Outram House Management Ltd
31 Granville Road
London SW18 5SB

FP/268/17/PL

We wish to object to aspects of the above Plans. Being close to this site, we are amazed there was no consultation over these plans

PROJECT	Gull Point Suites - On the Beach	DATE	20/09/17
TITLE	Roof Plan	DRG NO	IBA/480/10
SCALE	1 : 50	REVISIONS

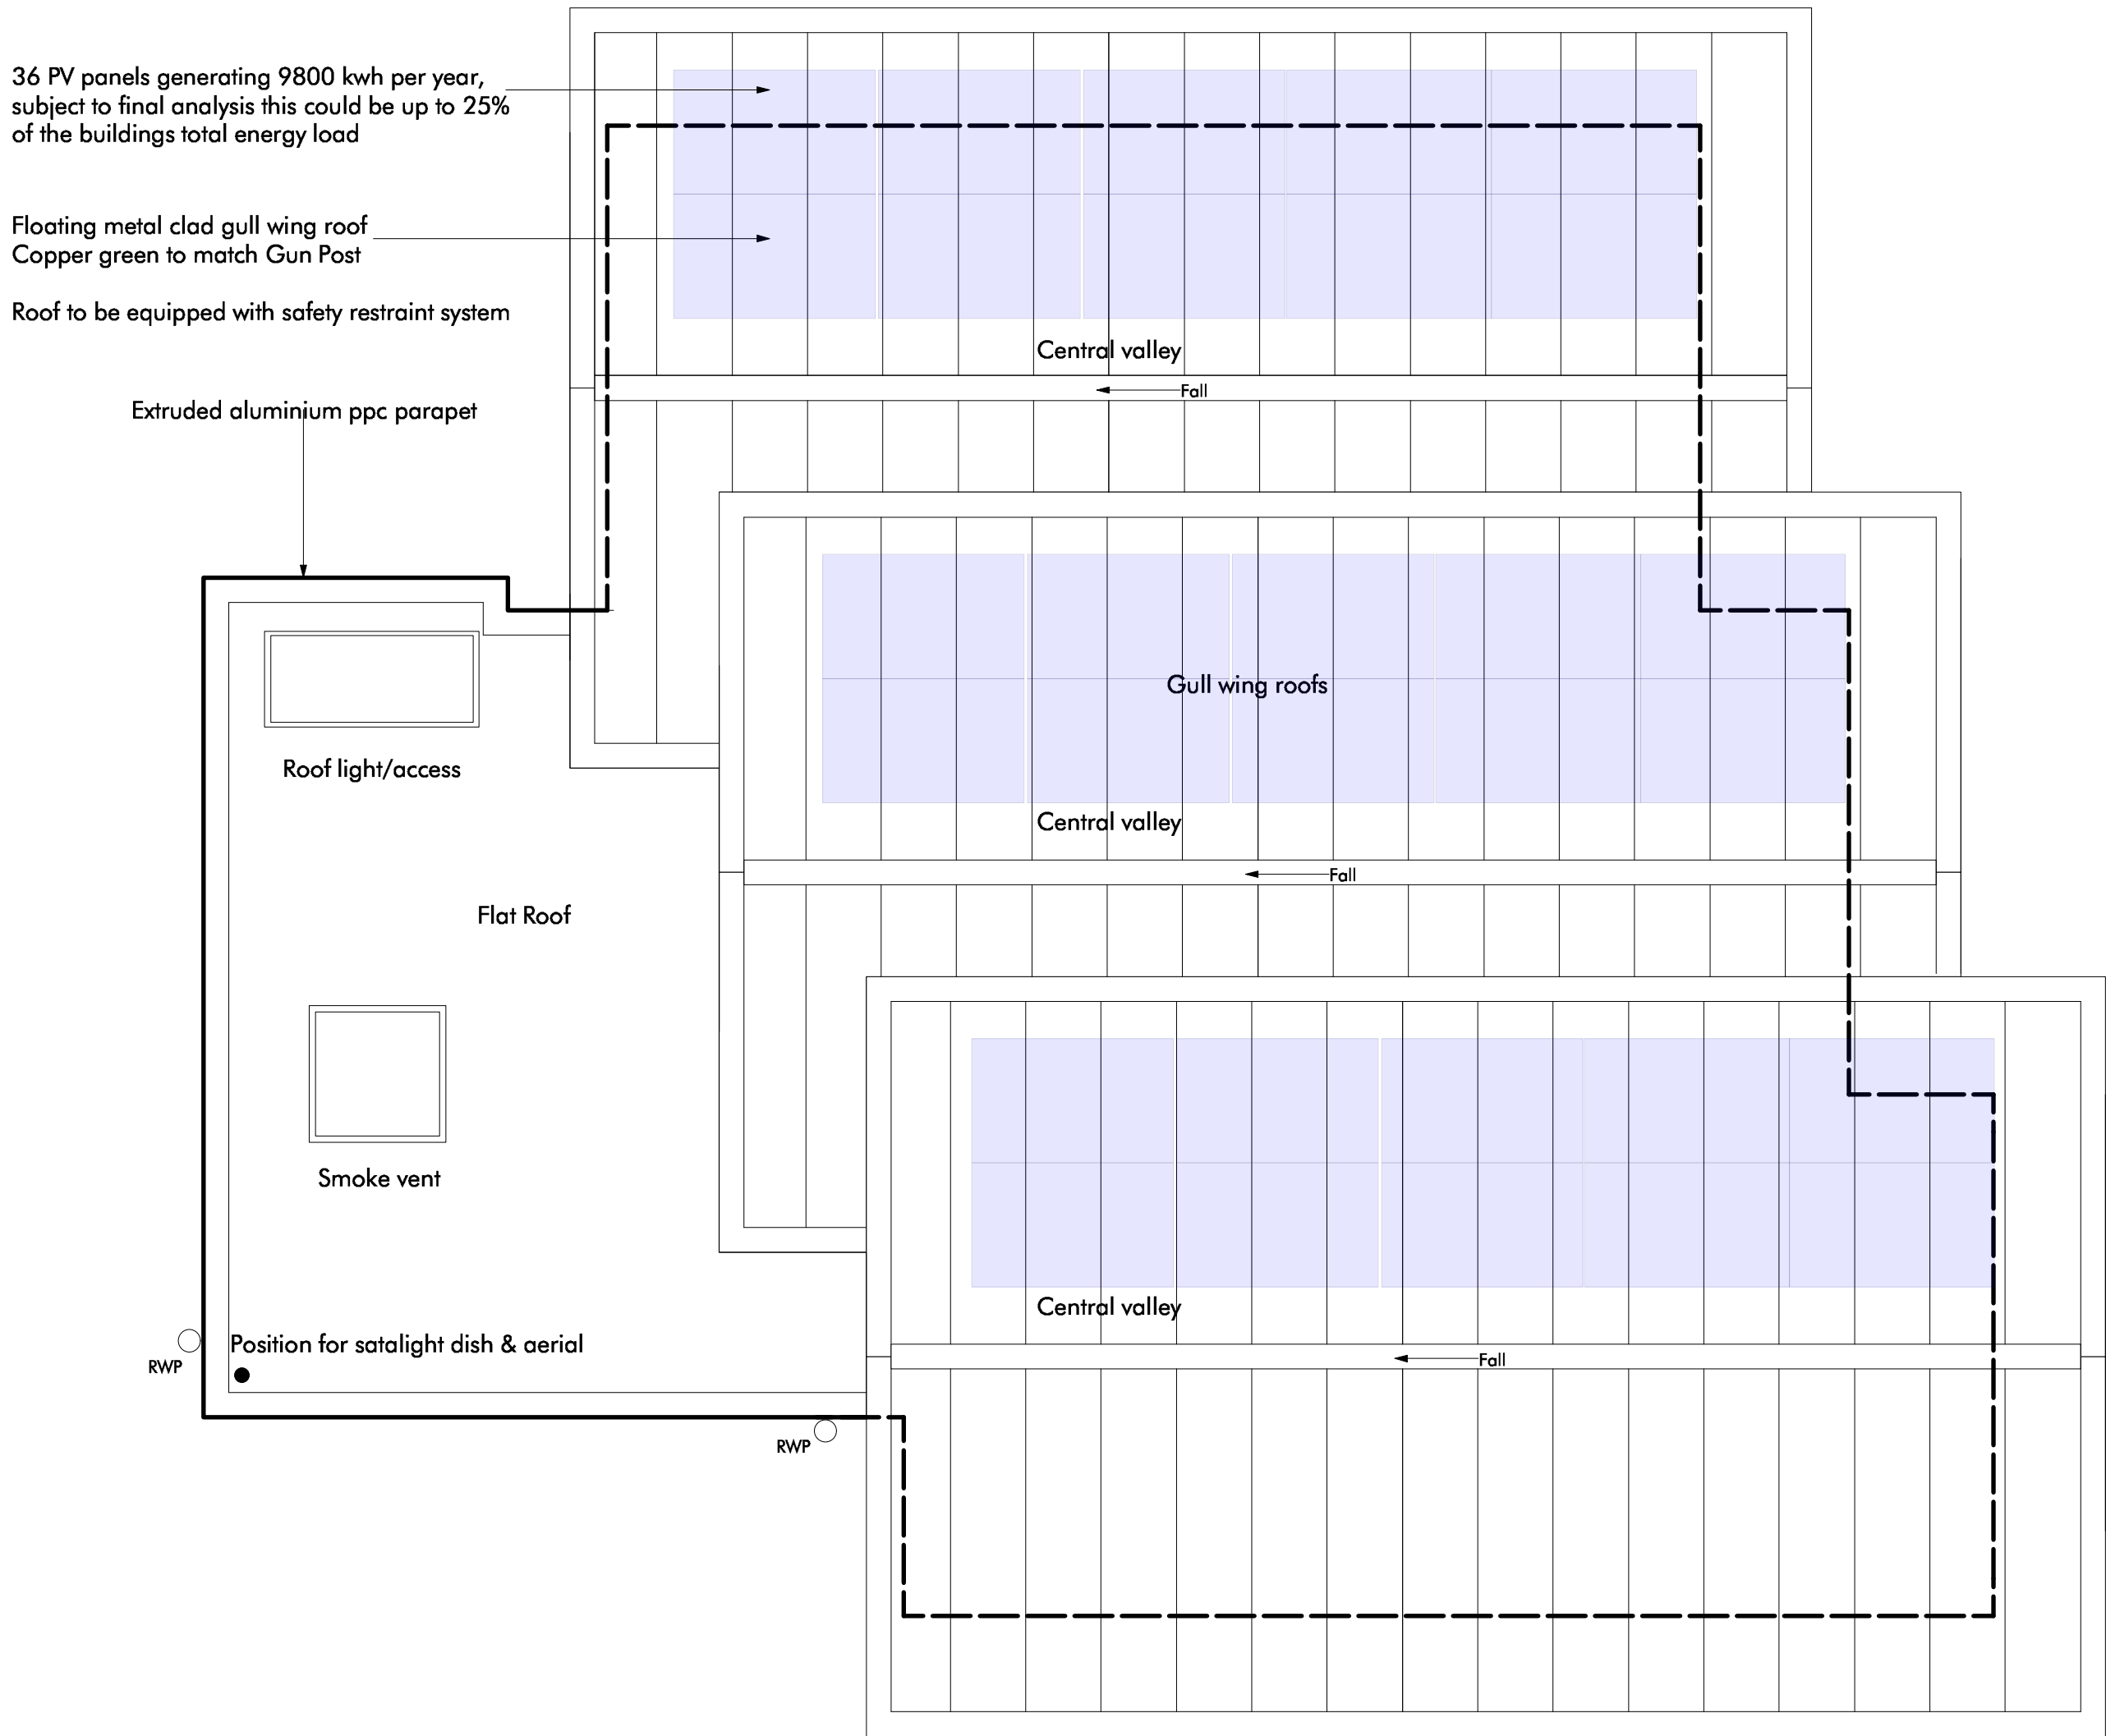
- 4 Height; The gull wing roof on top means the height is some way above the adjacent Gun Post. As the building and its balconies are so close to the prom, this means the height will appear even larger, spoiling the current pleasant aspect from the prom. (Will the gull wing roof be able to withstand gales??)

PROJECT Gull Point Suites - On the Beach
TITLE Typical Sections
SCALE 1 : 100
DATE 20/09/17
DRG NO IBA/480/09
REVISIONS

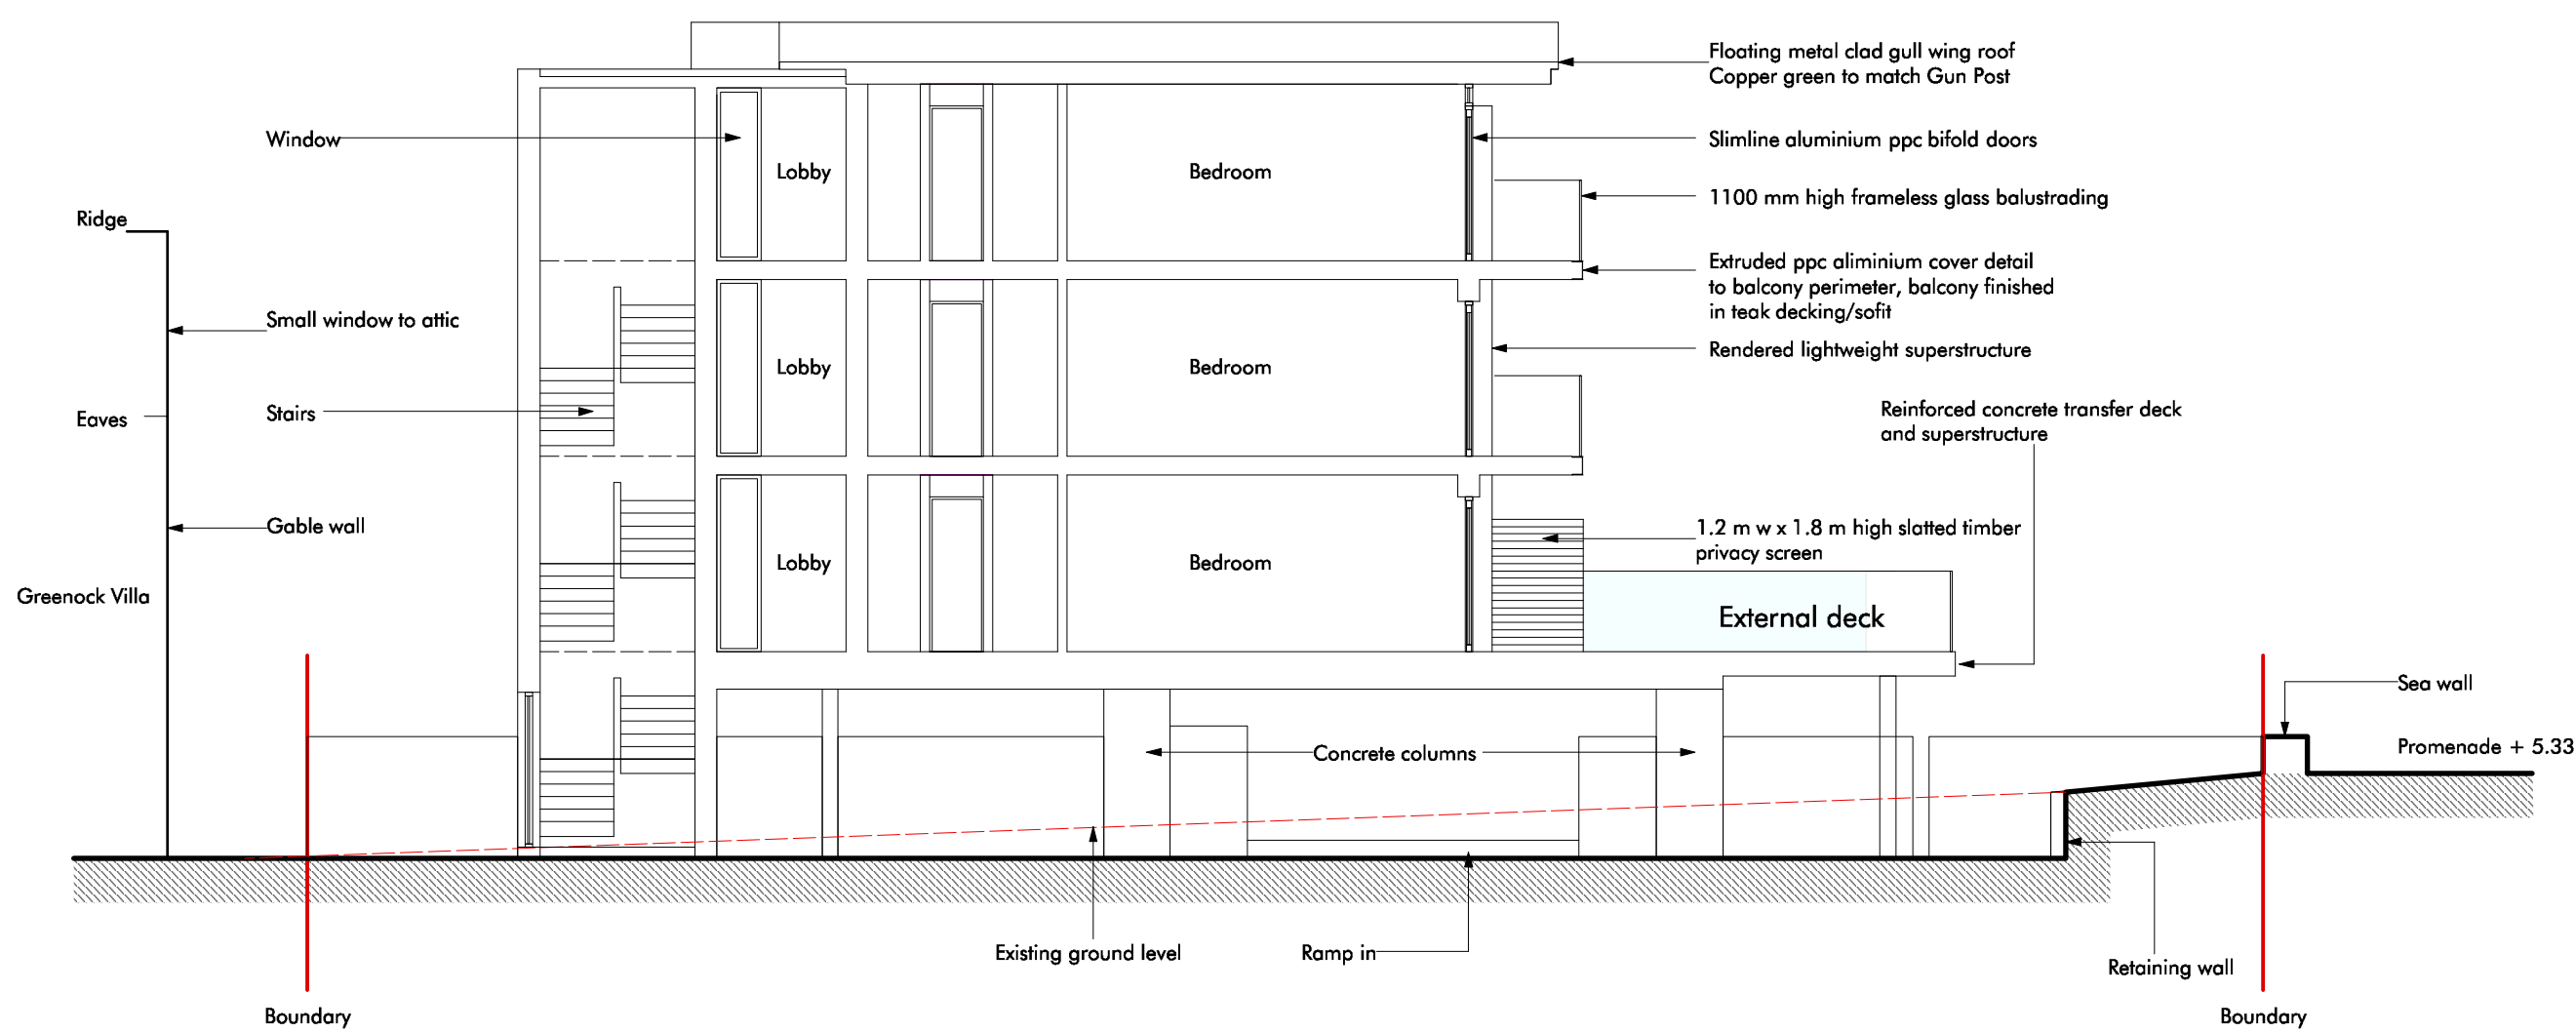
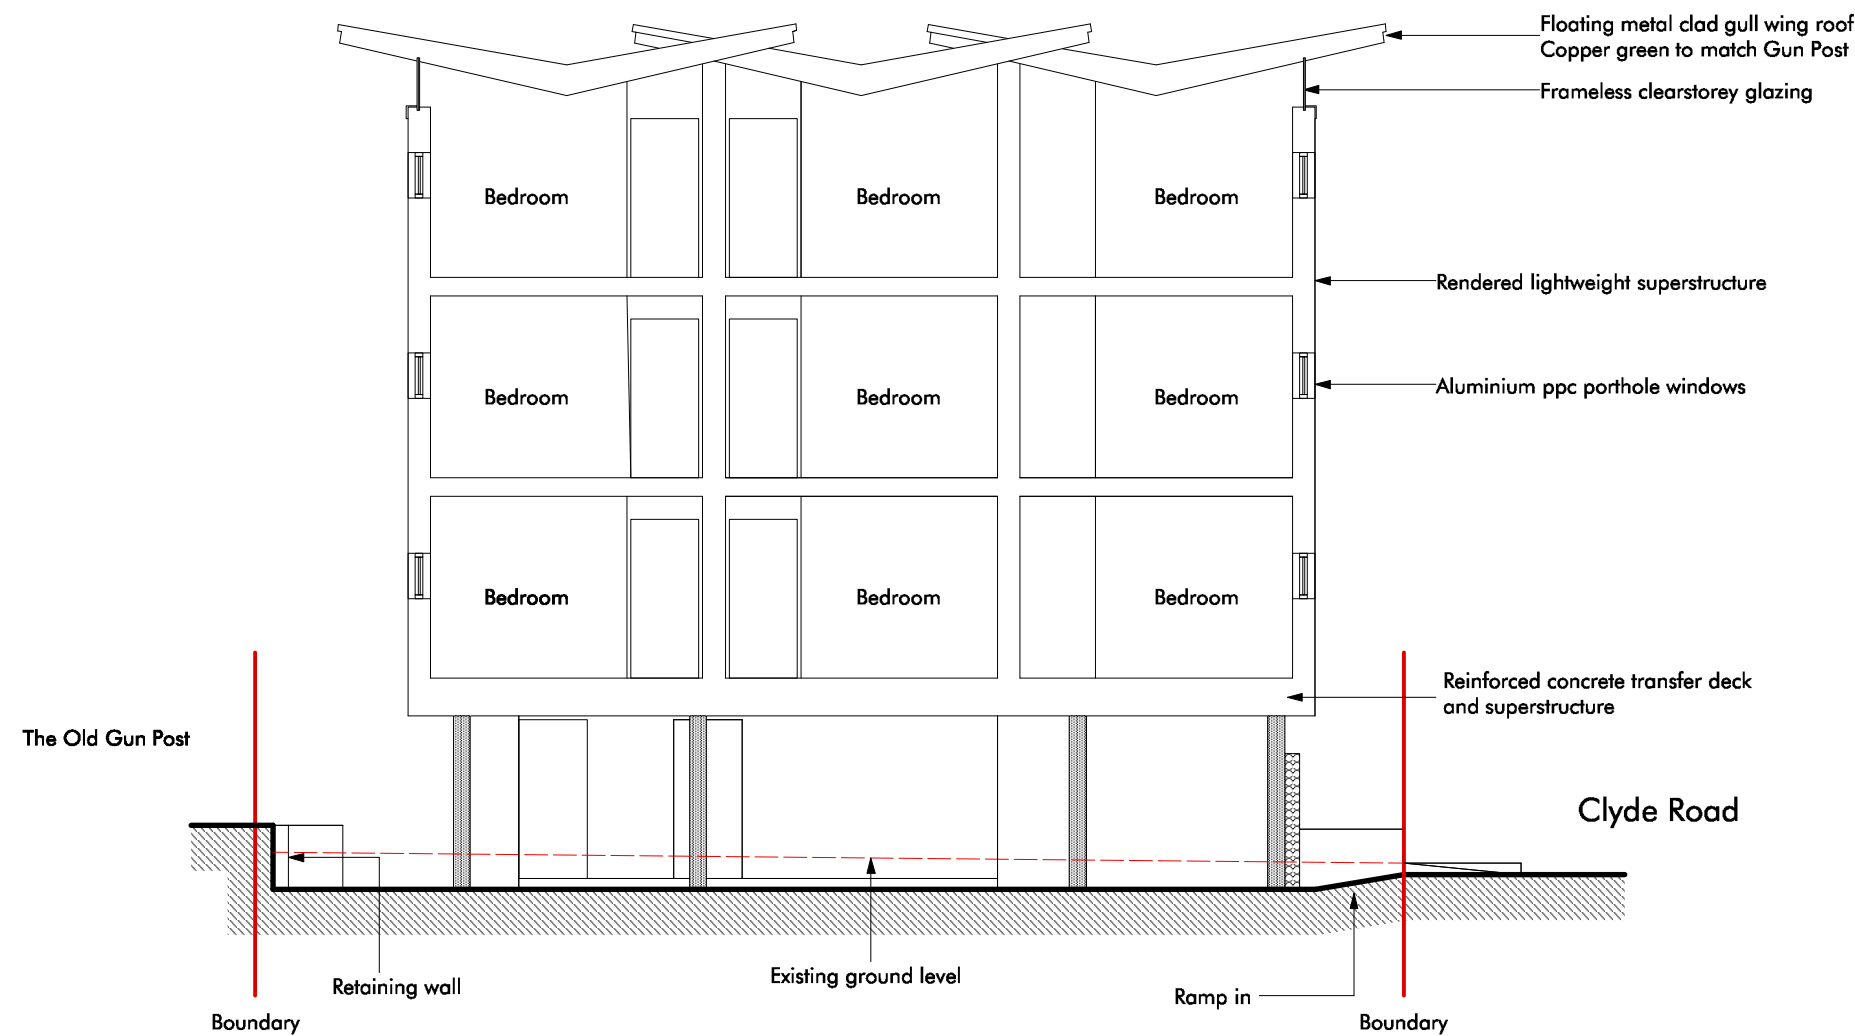
- 3 Height; It is FOUR storeys not 3 storeys high as indicated in the various documents. There is parking on the ground floor and three floors above that
